Applicant: Michael DiMillo - ^{Vesta} ~~Vest~~ Corp.

Address: 45 Ice Pond Rd
Old Bern Estates, Lot 10

CHECK-LIST AGAINST ZONING ORDINANCE

Proposed Use/Work - build single family one-story home

PROJ. NO.  
 DWG. NO.  
 SITE PLAN

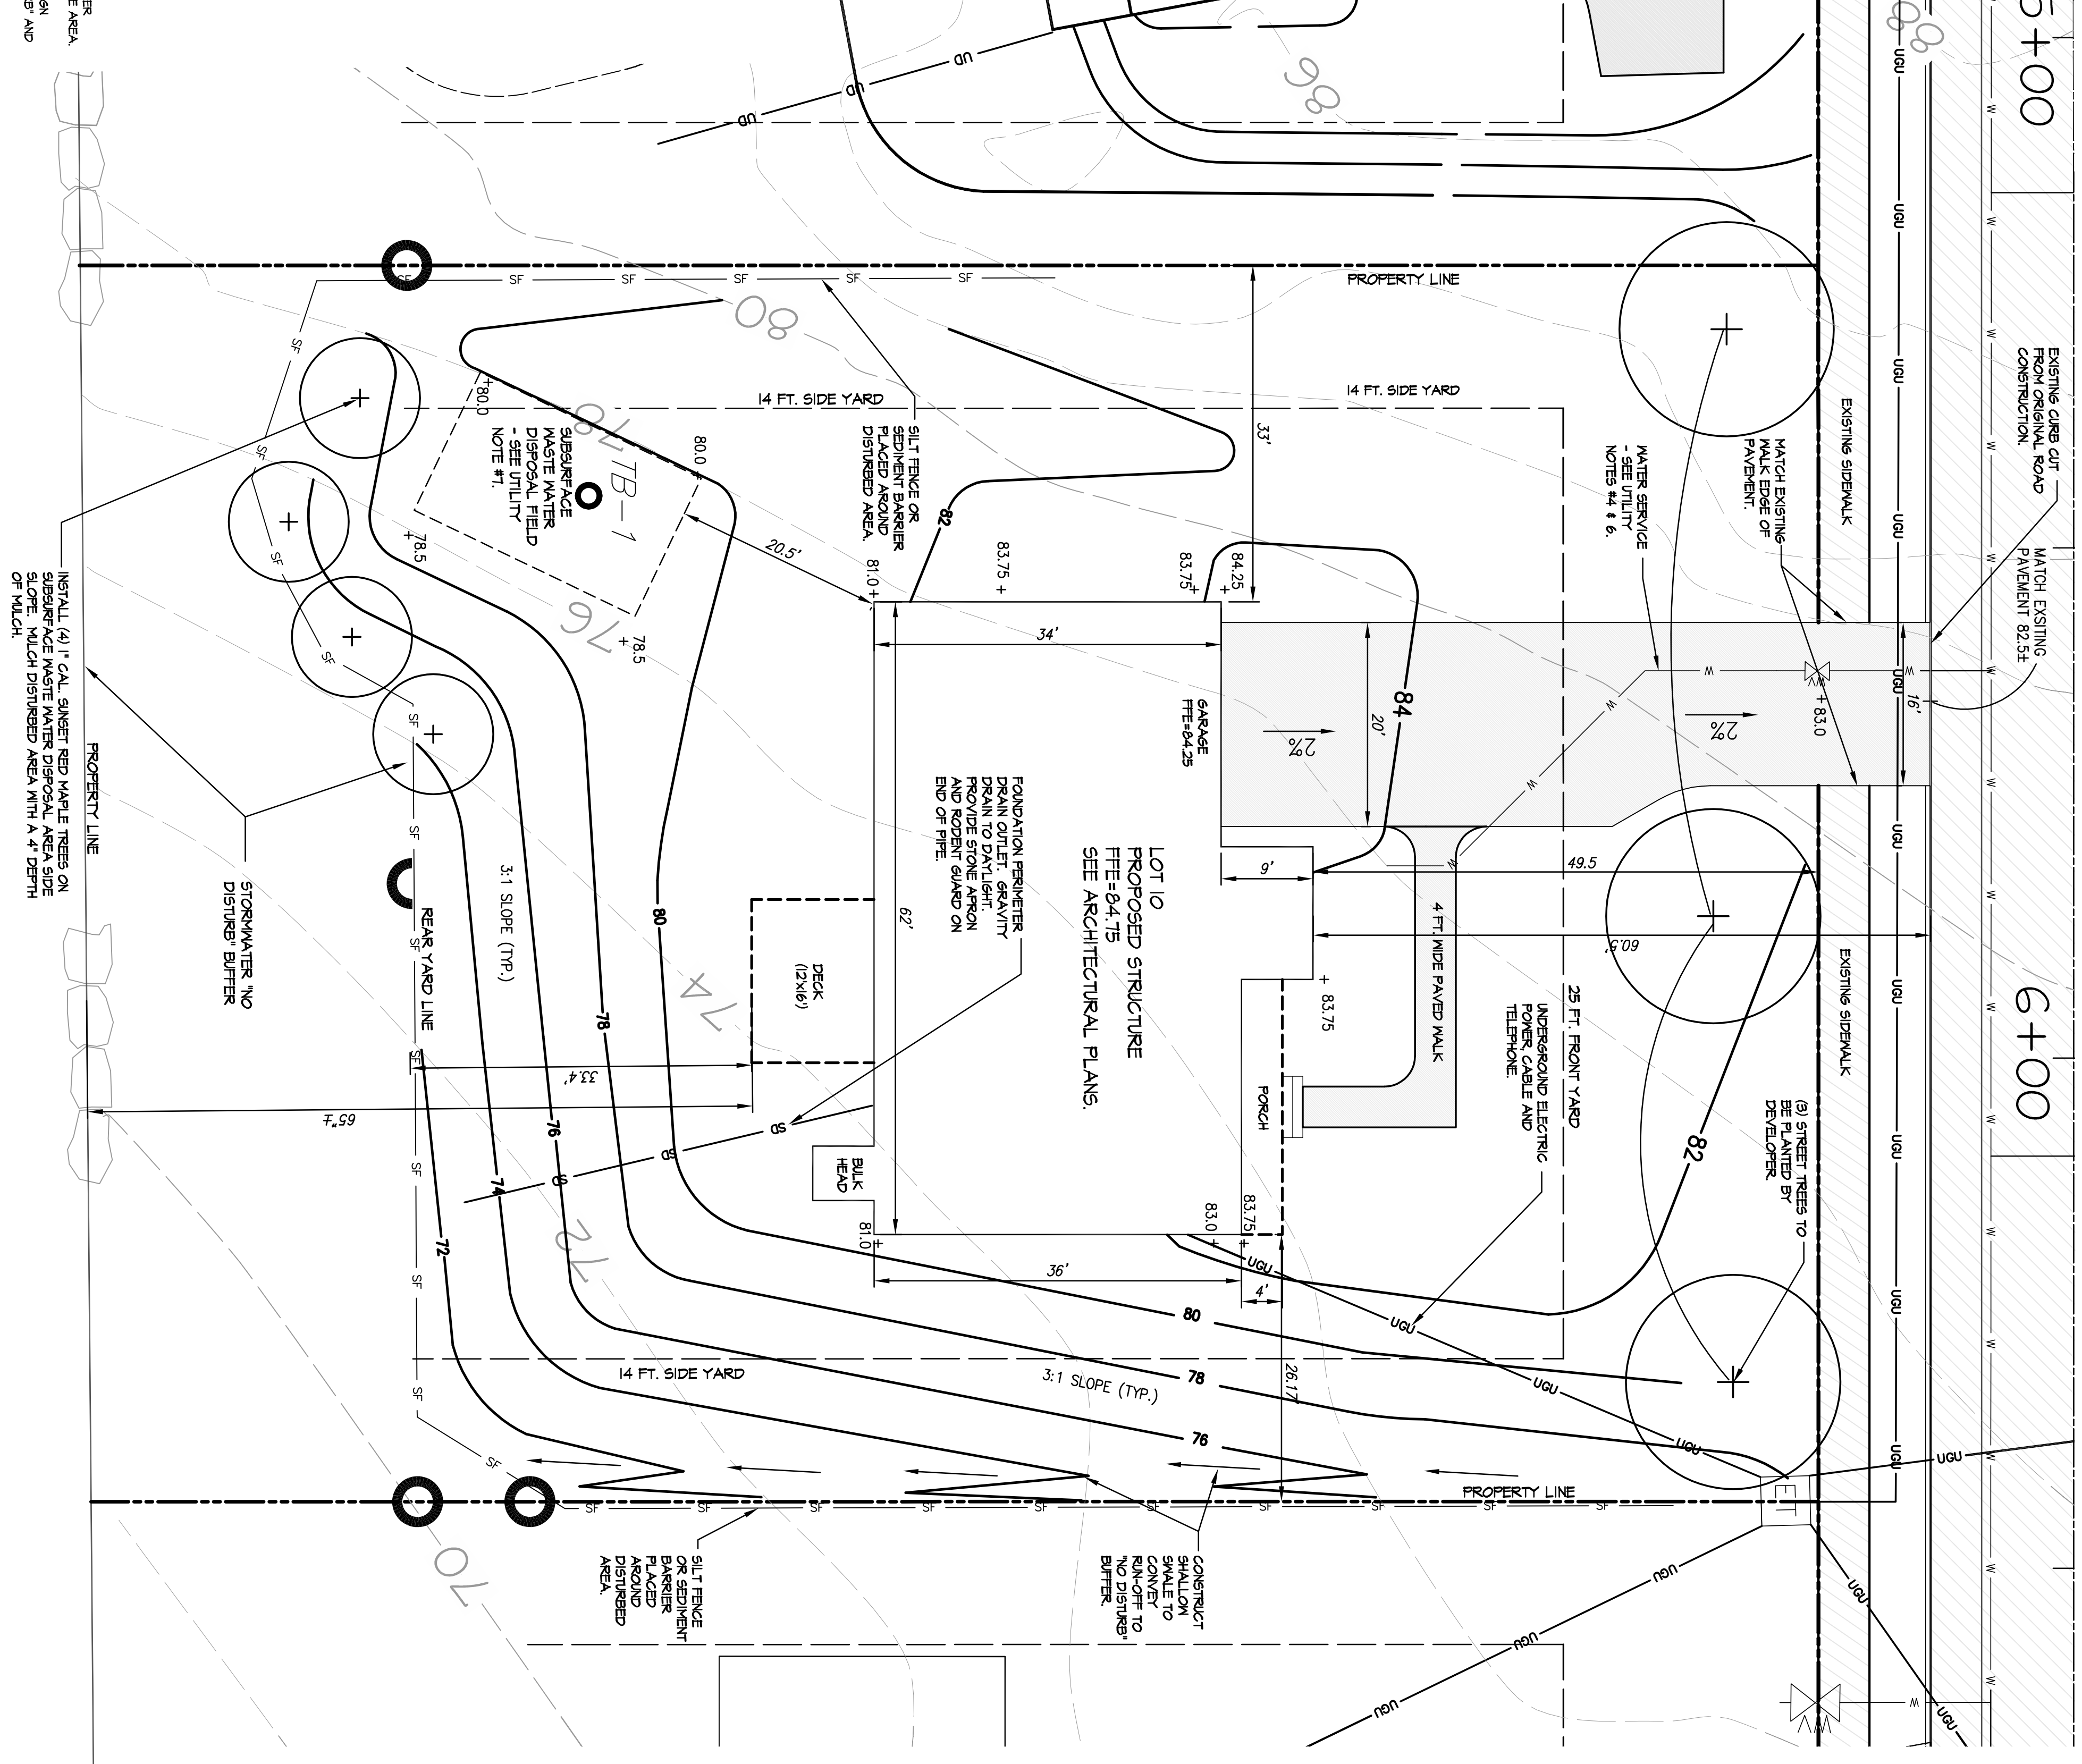
Front Yard - 25' min - ^{44.5' 5' min} ~~42.5' scaled~~ OK

Rear Yard - 25' min - ^{65' given} ~~33.4' scaled to deck~~ OK

Side Yard - 8' min. - left - 26.3' scaled OK
- right - 33' scaled - OK

Lot Coverage Impervious Surface - 35% = 4113.4 7198.5 sq ft
